KITITAS COUNTY

MEMORANDUM

TO: All Staff
FROM: Public Works Planning Review Team
DATE: April 20, 2021
SUBJECT: LPF-21-00004 Suncadia Phase 2, Division 1

A BIOINFILTRATION SWALE DETAIL

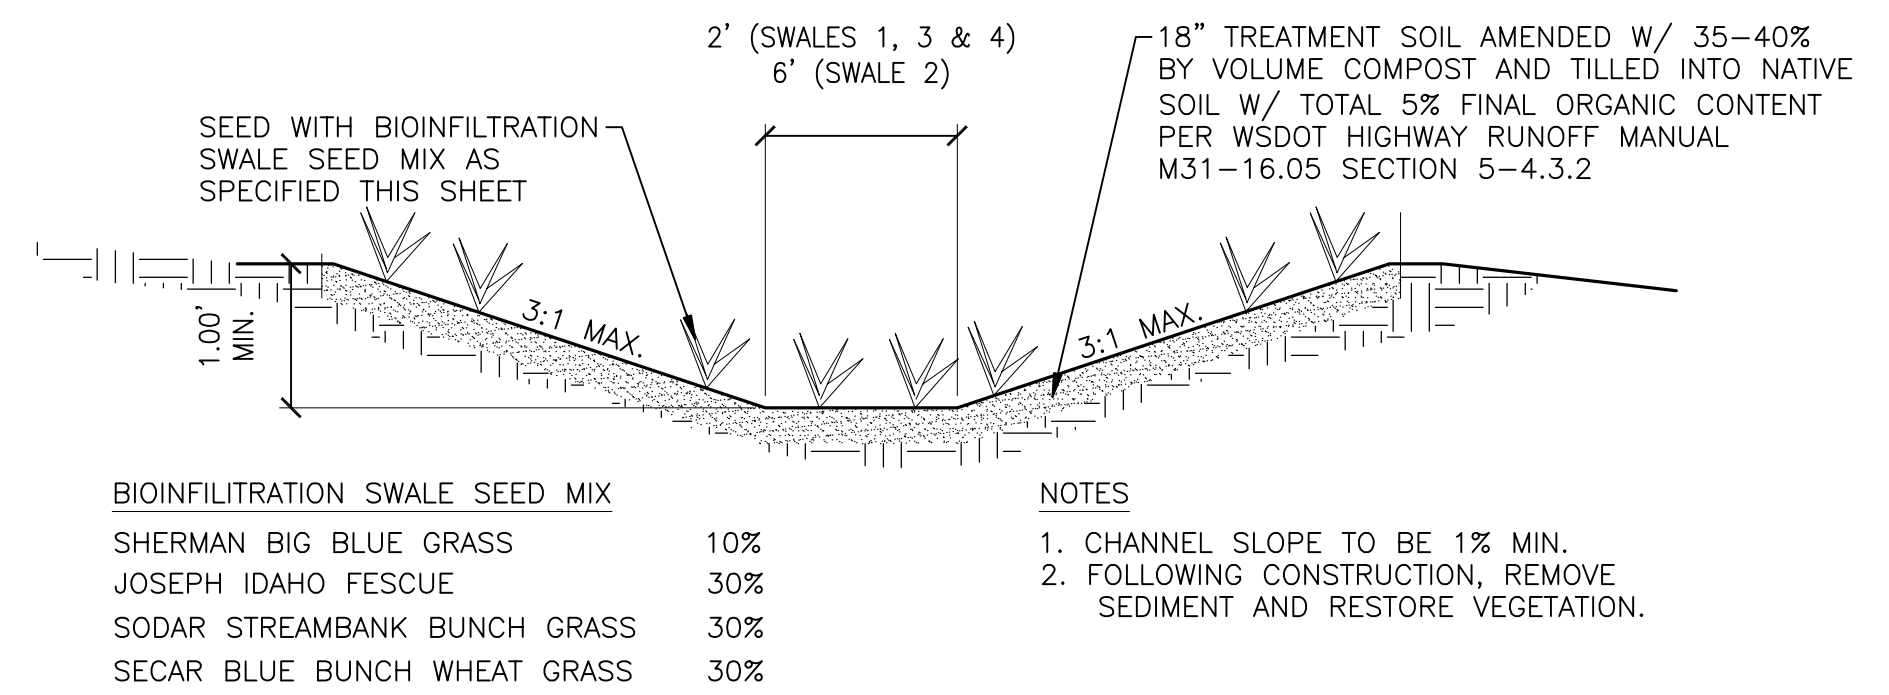
3. On page 10 of the drainage report, it is explained that water quality will be handled through an 18" layer of engineered soil as recommended by the Geotech report. Public Works was unable to find any reference to these engineered soil in the Geotech report. At a minimum, Public Works needs to see description of the engineered soil and whether or not the soil meets the requirements of SSC-6 in the Stormwater Manual.

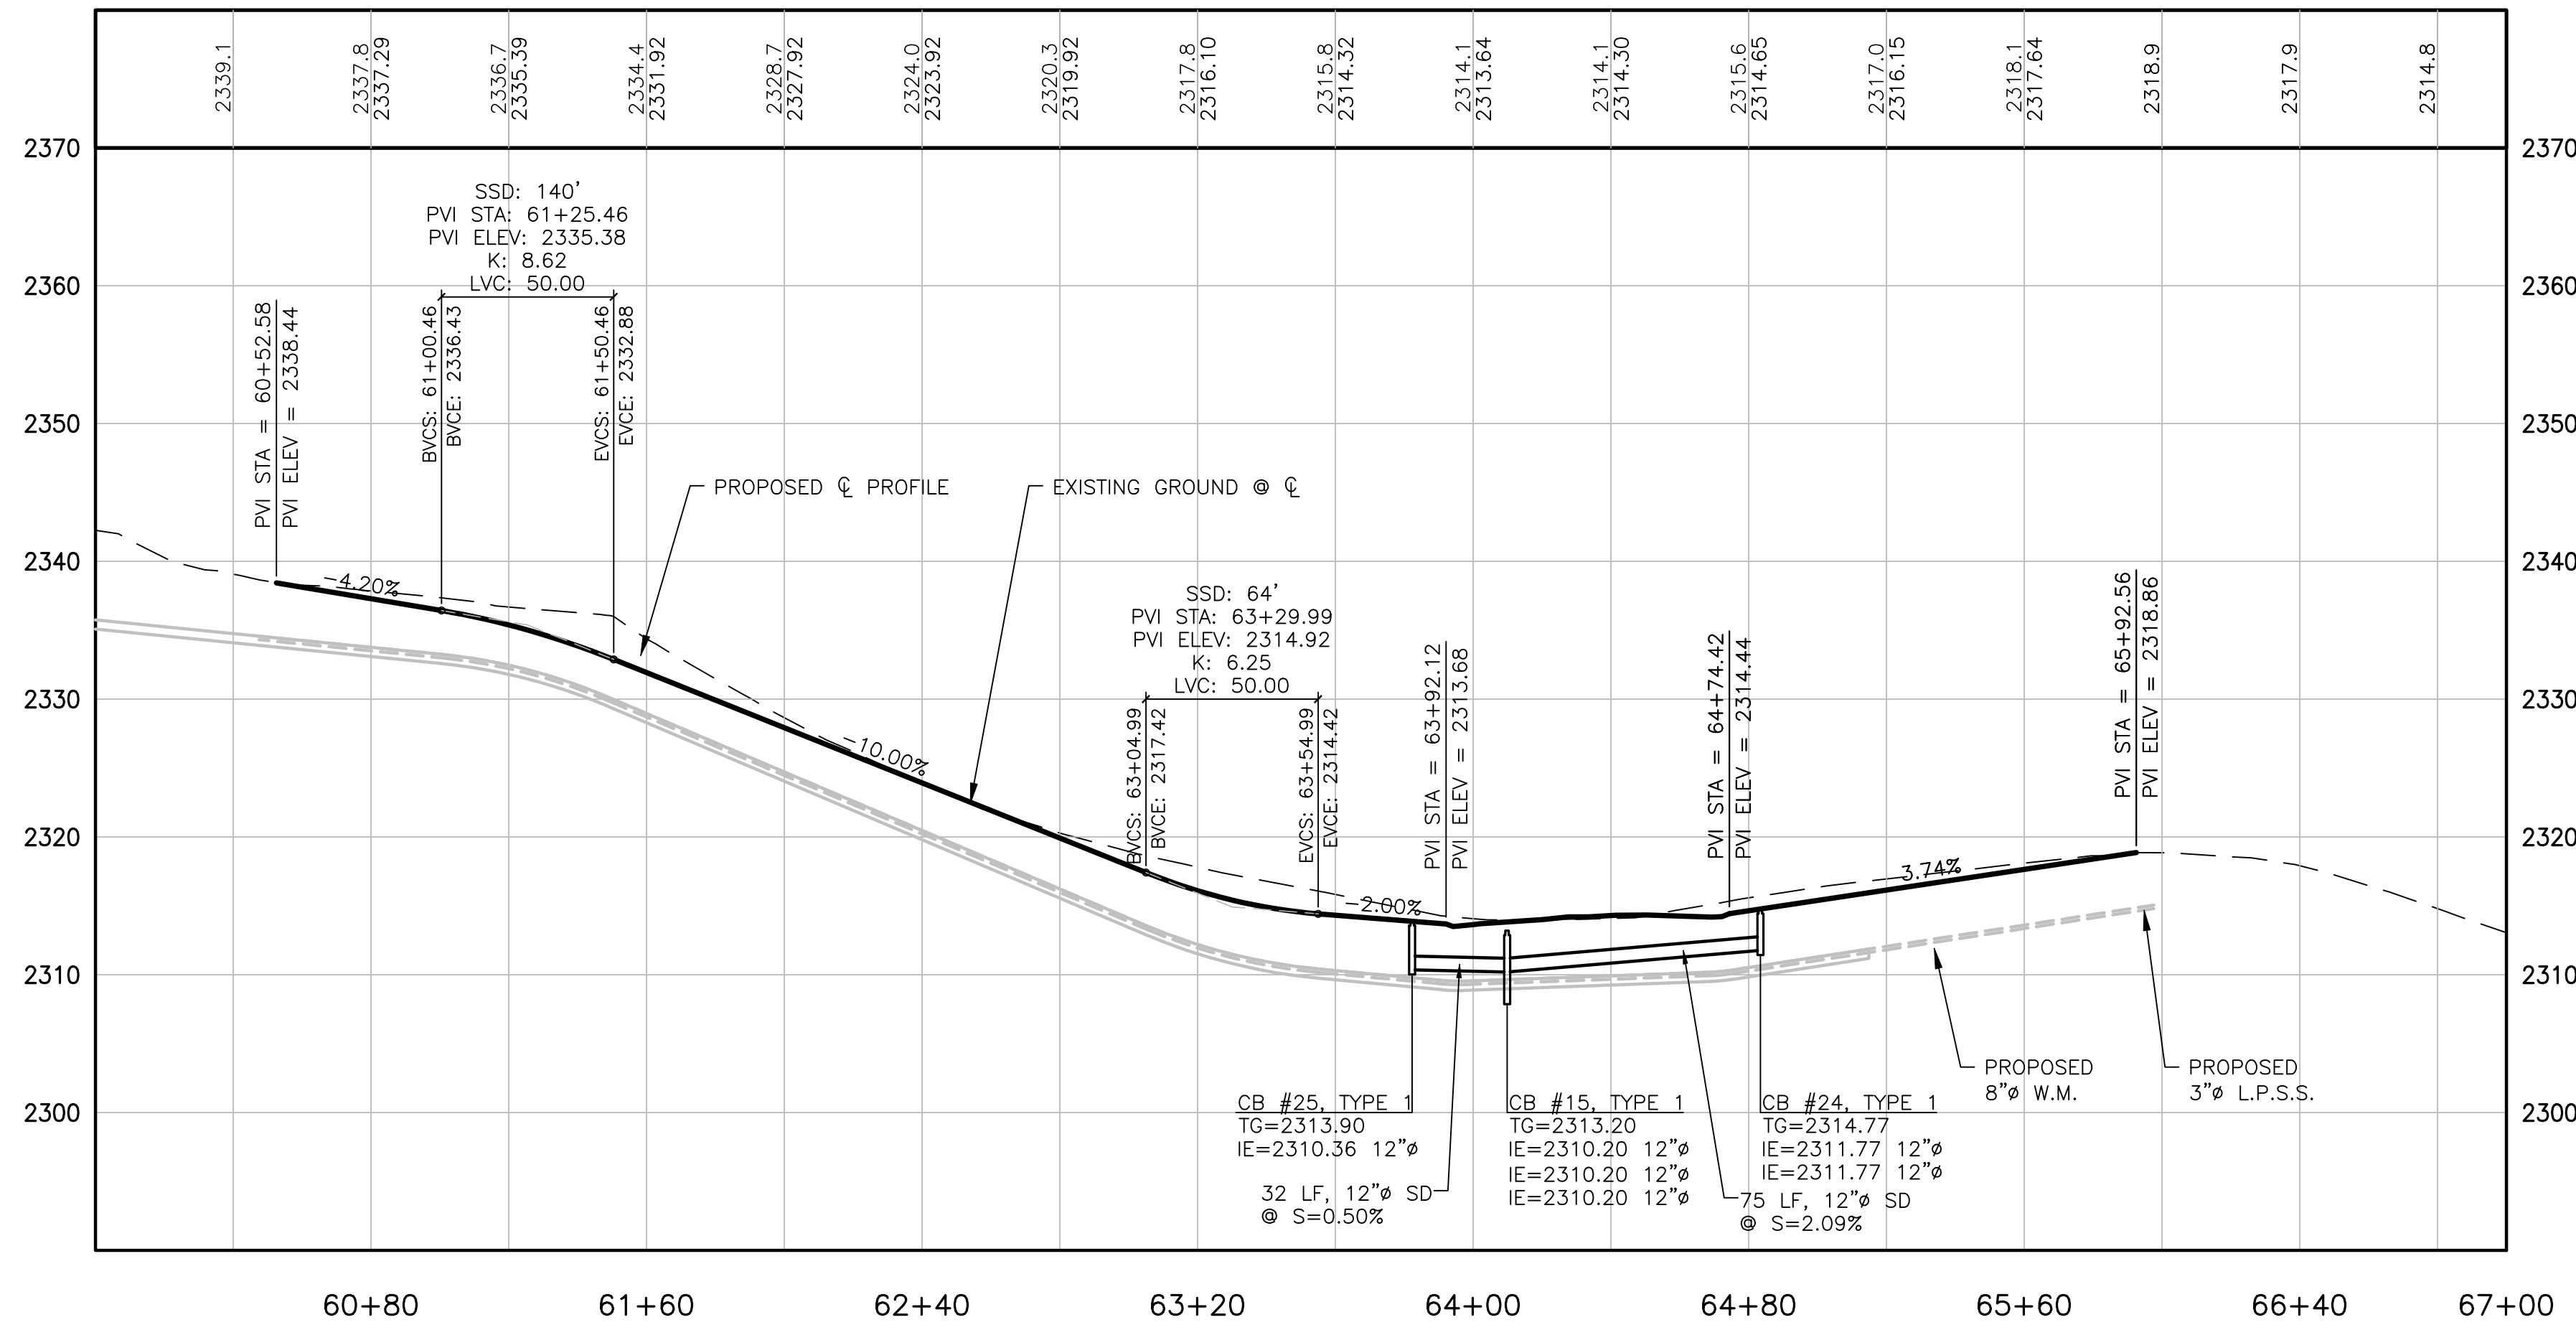
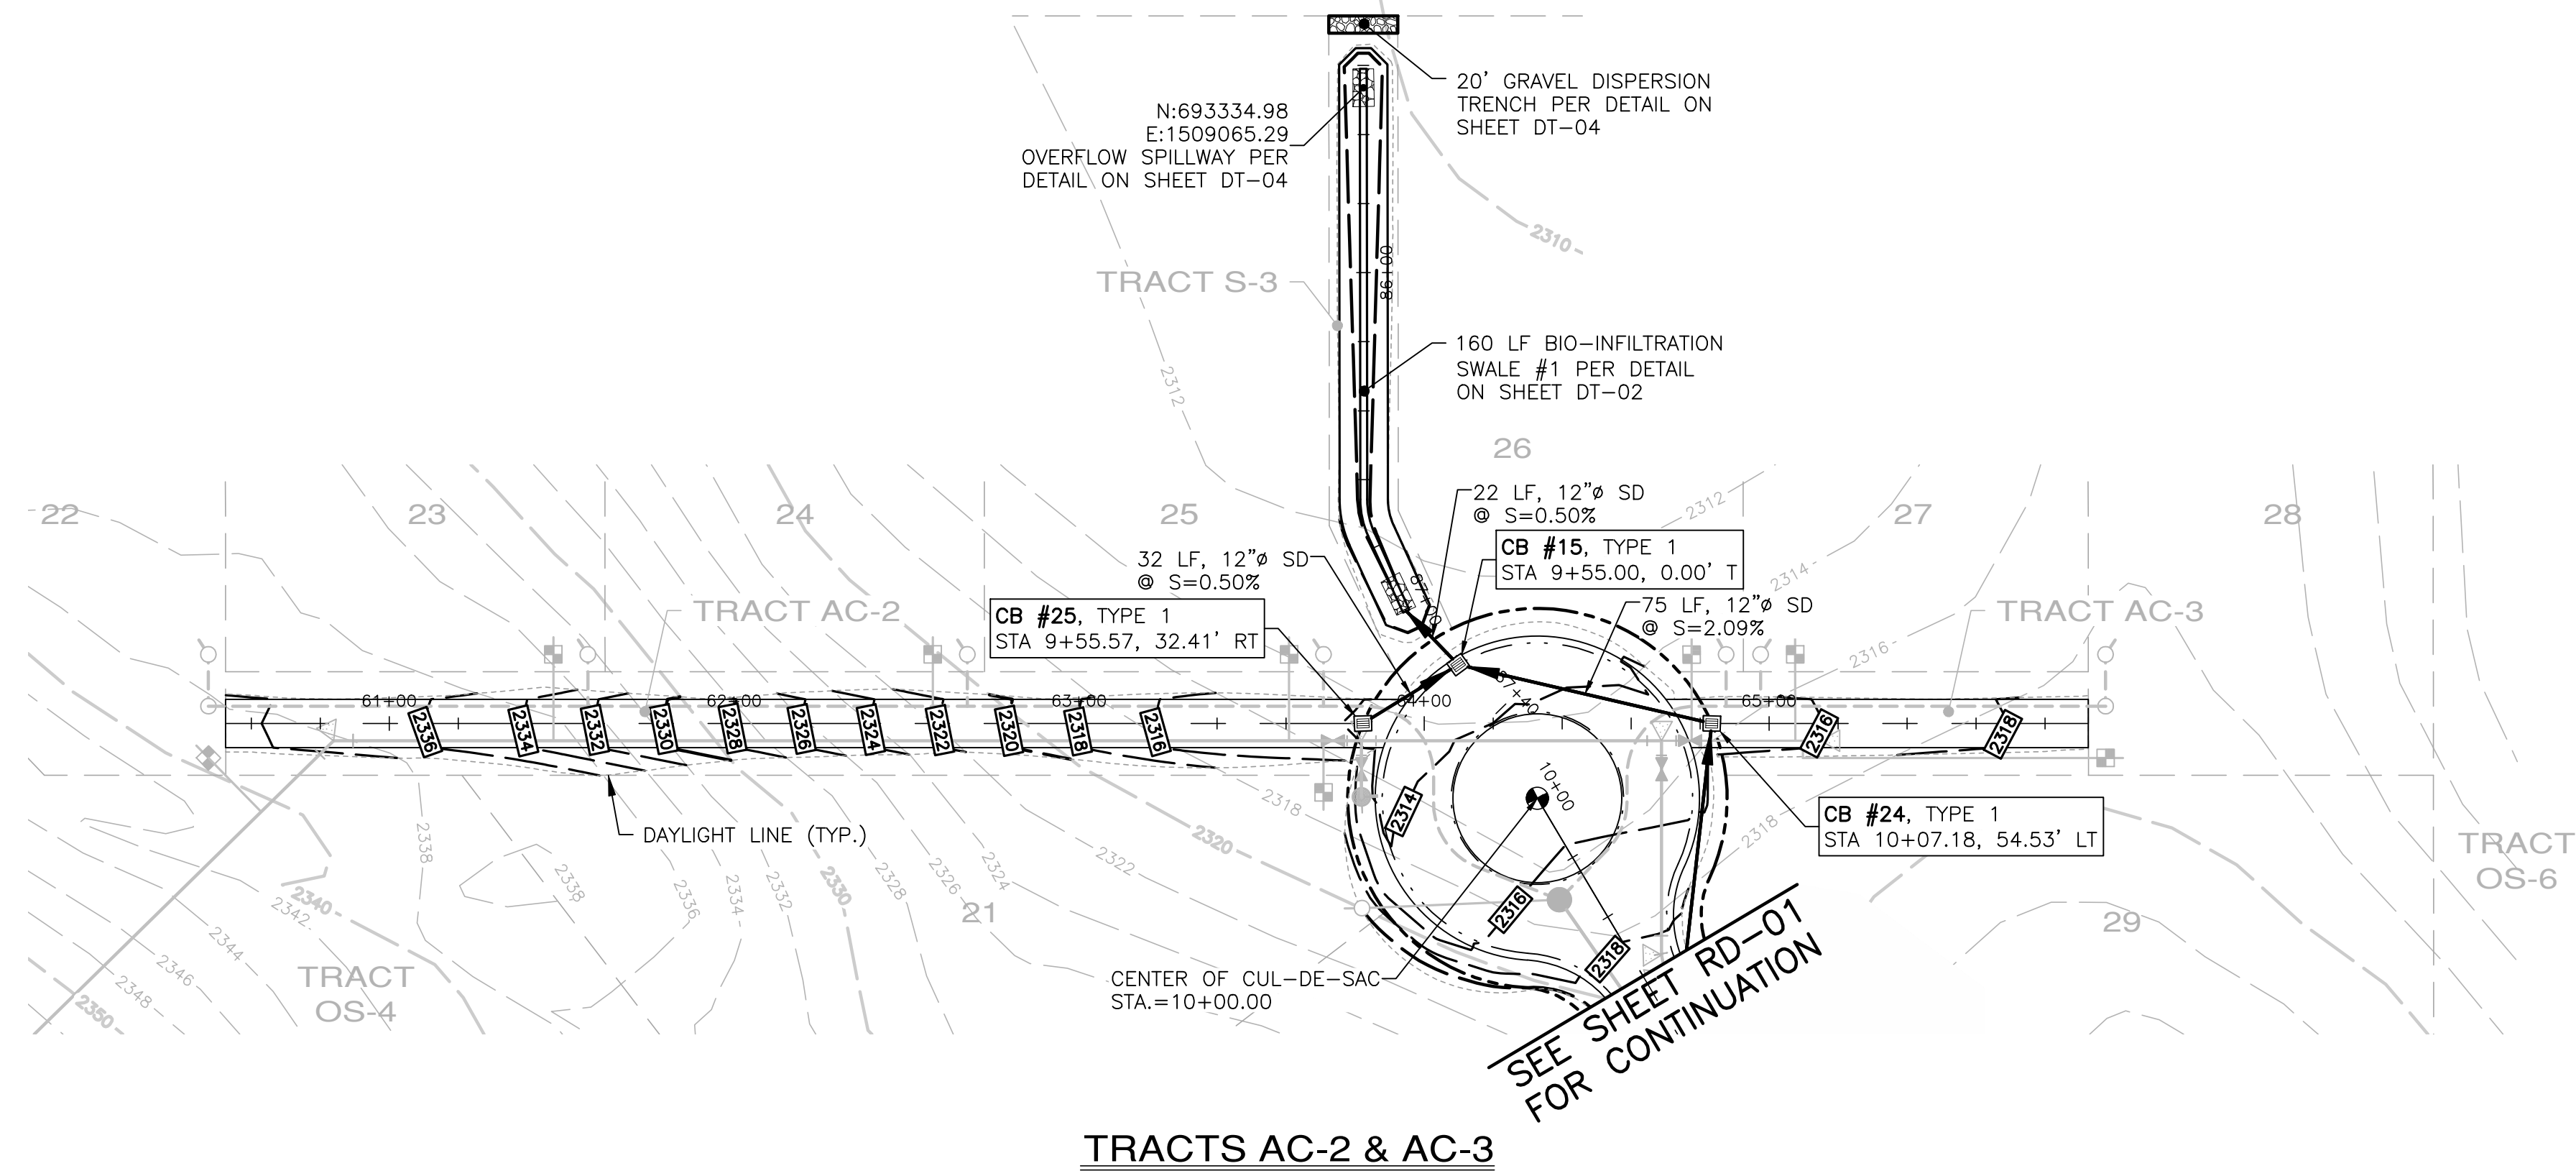
1. On sheet RD-04, labels for the bio infiltration system are incomplete. The station label is currently listed as "???, ???' ???T".
2. On page 10 of the drainage report, a flow separation system is described which will evenly split the runoff from Basin A into the two drainage swales. On the plan set, a type 1 catch basin is shown with two pipes coming out of the same side. Please provide a detail on how this system will function to ensure that flow is separated as intended.
